## Appeal Decisions

**Decision date: 28 September 2022**

### **Appeal A, Ref: APP/R5510/C/21/3278948**

#### **27 Woodstock Drive, Ickenham, Uxbridge UB10 8EG**

Drawn by: Zodiac Design
Date: 21 August 2018 Details are NTS
Drawing No: ZD/2018/27WD-8 Revision: C

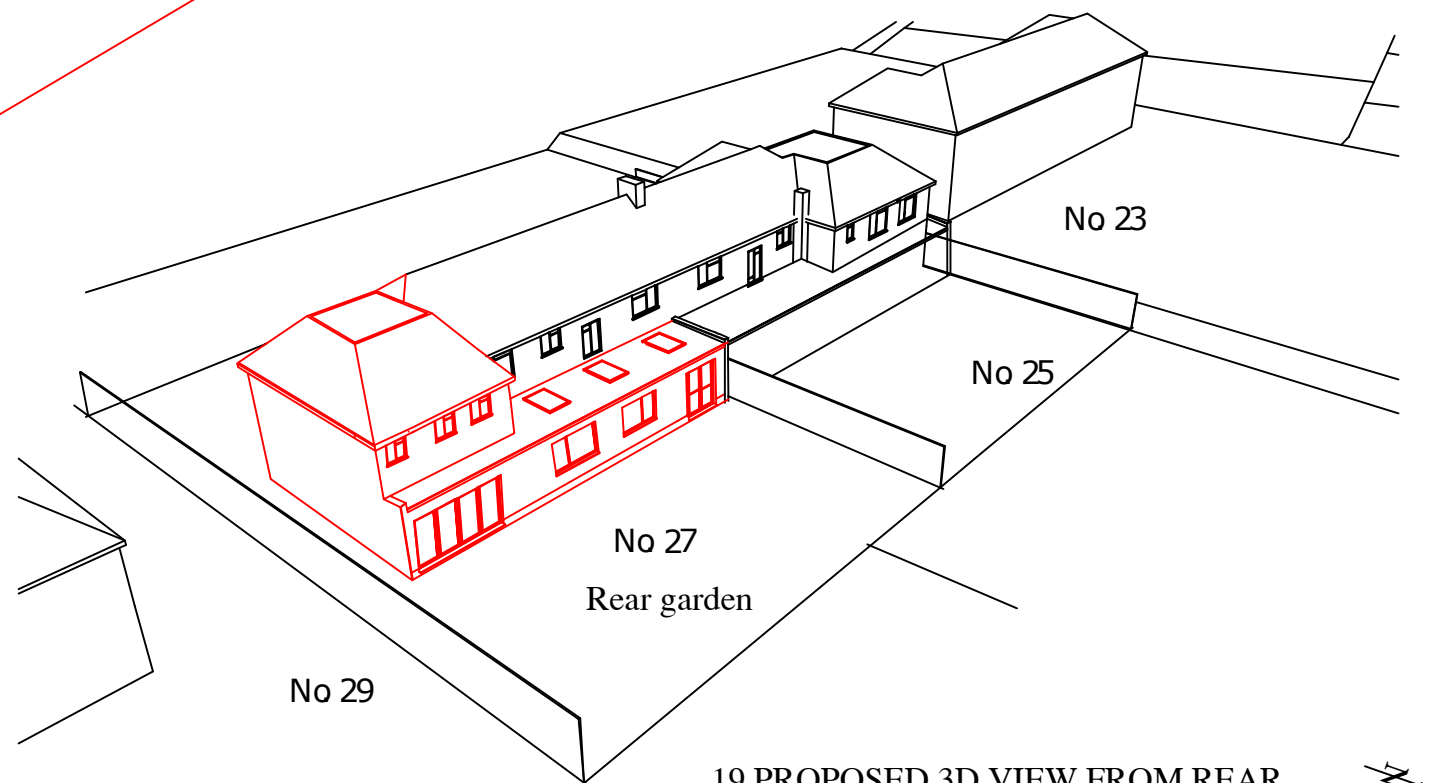
- (v) reconstruct part 2 storey, part single storey side extension so that it is in full accordance with the plans approved by planning decision ref 61790/APP/2018/1659 dated 24 August 2018 (Part two storey, part single storey side/rear extension and canopy to front involving demolition of existing garages), namely drawing numbers ZD/2018/27WD-3 Rev B, ZD/2018/27WD-5 Rev C, ZD/2018/27WD-7 Rev C, ZD/2018/27WD-6 Rev B, ZD/2018/27WD-8 Rev C, ZD/2018/27WD-1 Rev B; and

Drawn by: Zaidine Design
Date: 21 August 2018
Drawing No: ZD/2018/27WD-7
Revision: C

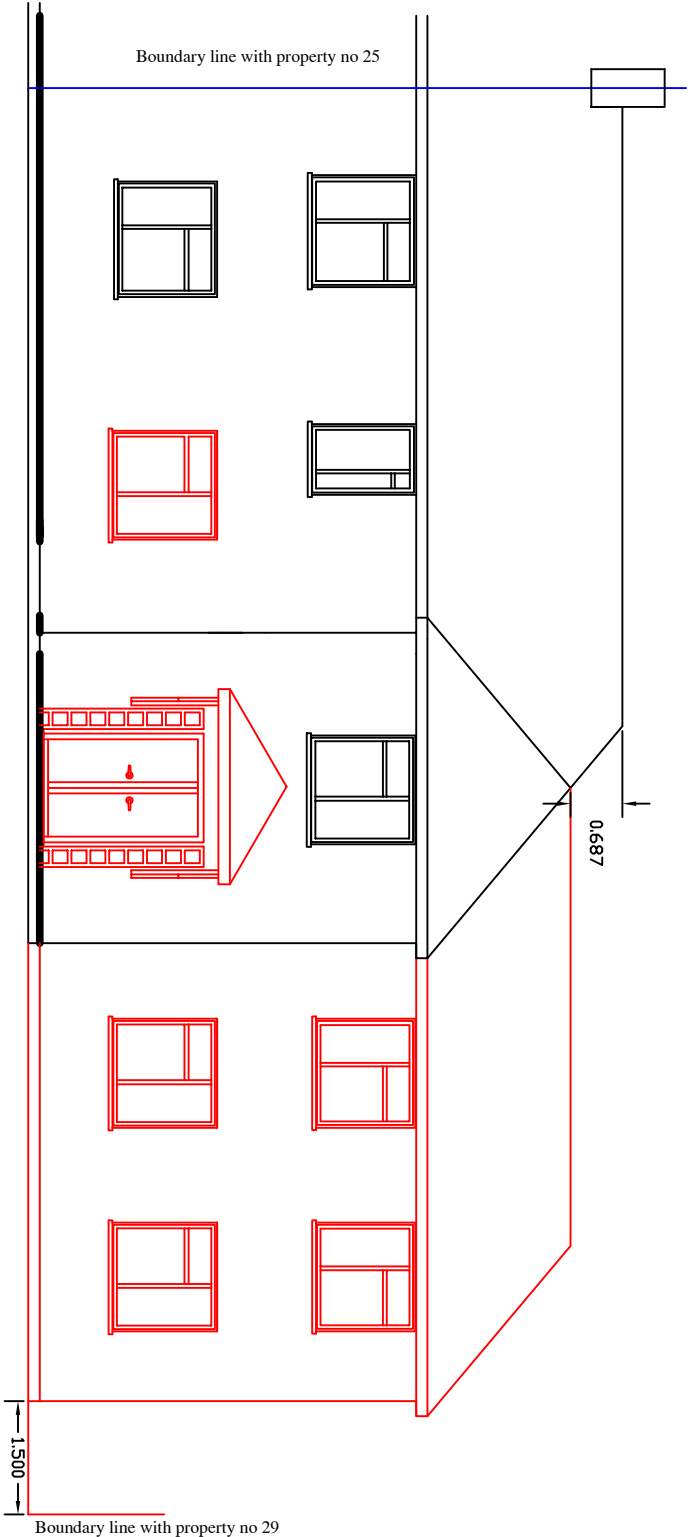
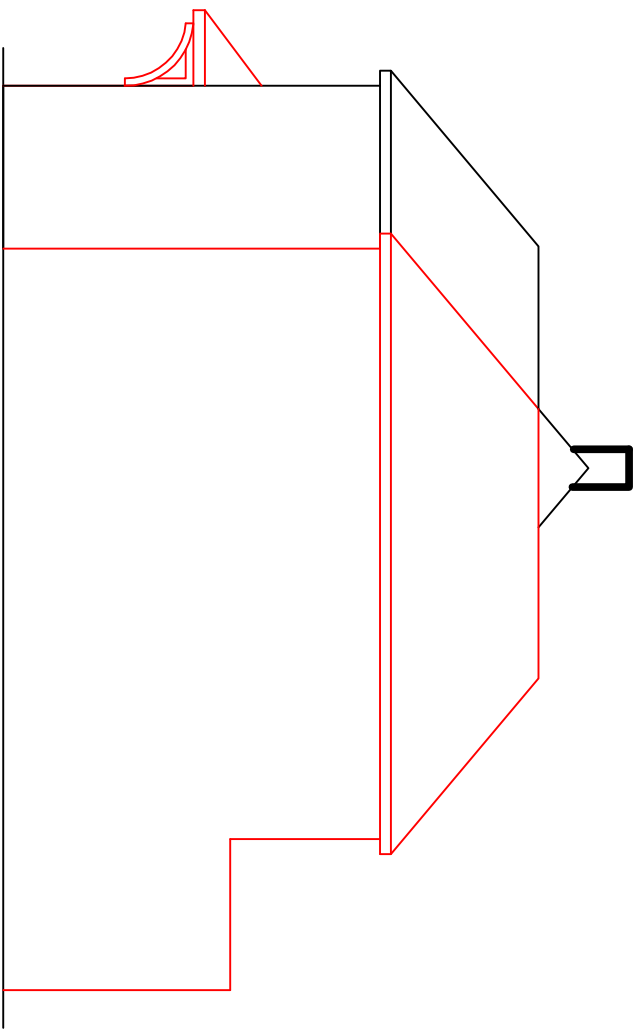
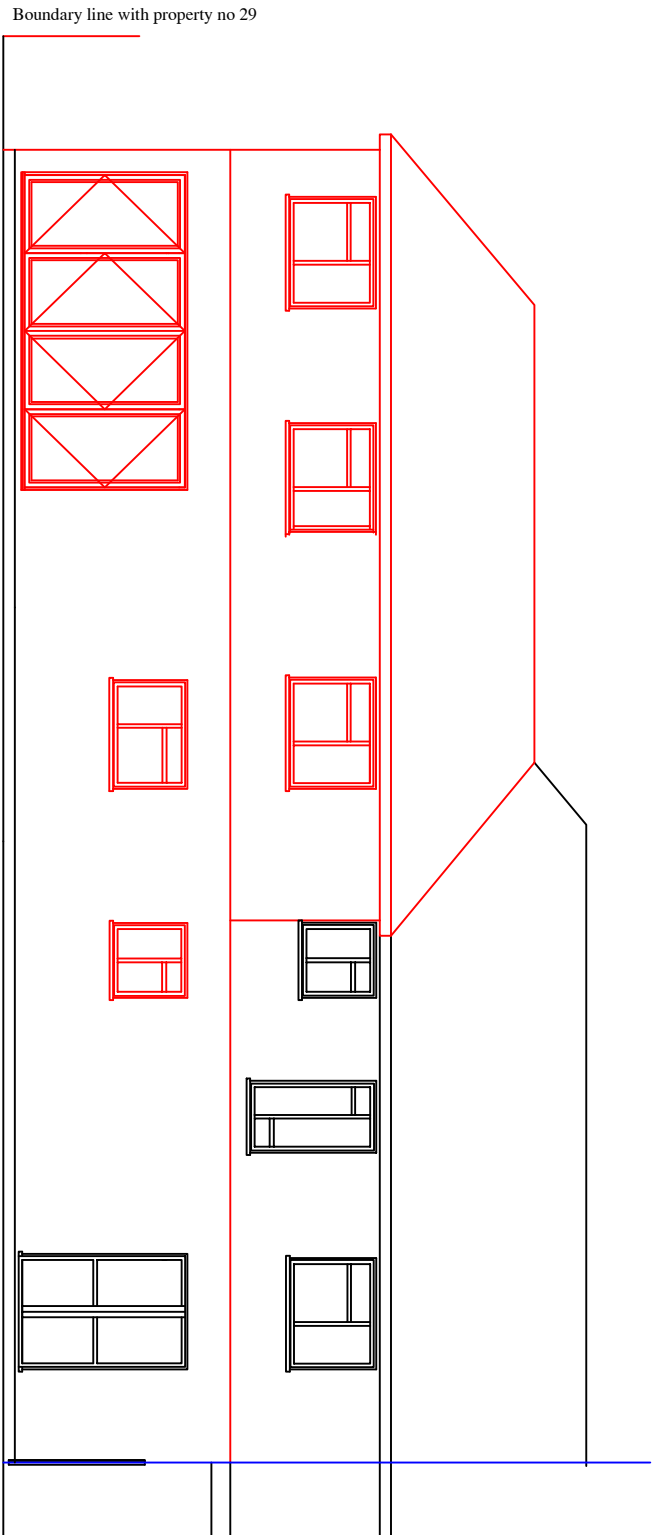
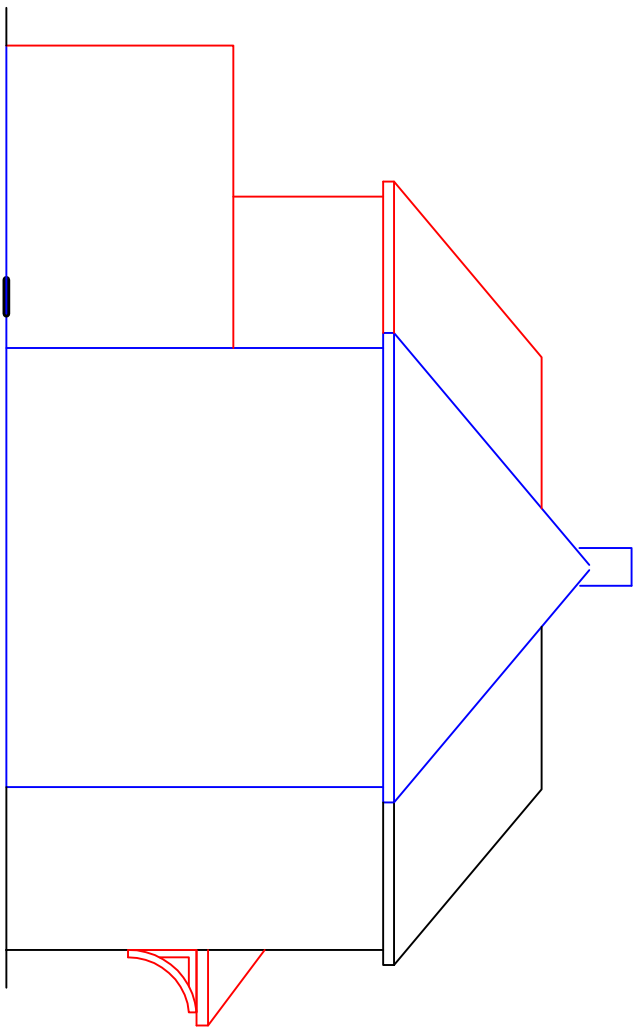
15. The approved plans for the two storey side extension at the appeal site also show that it would be in line with the main front wall of the building. As such, visual symmetry would be restored, in terms of massing, although the fenestration would differ from that at No 25. Whilst the side extension at the appeal site has been built slightly wider (1m according to the Council) than the approved dimension, this does not detract from the restoration of the visual symmetry of the semi-detached pair.

16. Policy DMHD 1 of Hillingdon's Local Plan: Part Two<sup>1</sup>(LP2) requires that side extensions should not exceed half the width of the original property and that two storey side extensions should be set in a minimum of 1m from the side boundary. The approved 2018 extension plans show a 1.5m set in from the boundary but the width of the two storey side extension would have been 6m, which was more than half the width of the original house at 11.5m. However, LP2 was adopted after the 2018 planning permission.

- (i) The development hereby permitted shall not be carried out except in complete accordance with the details shown on the submitted plans, insofar as they relate to the two storey side extension and the part single storey side extension only and excluding the two single storey front extensions, numbers: PL/A515/01, PL/A515/02, PL/A515/03 and PL/A515/05;
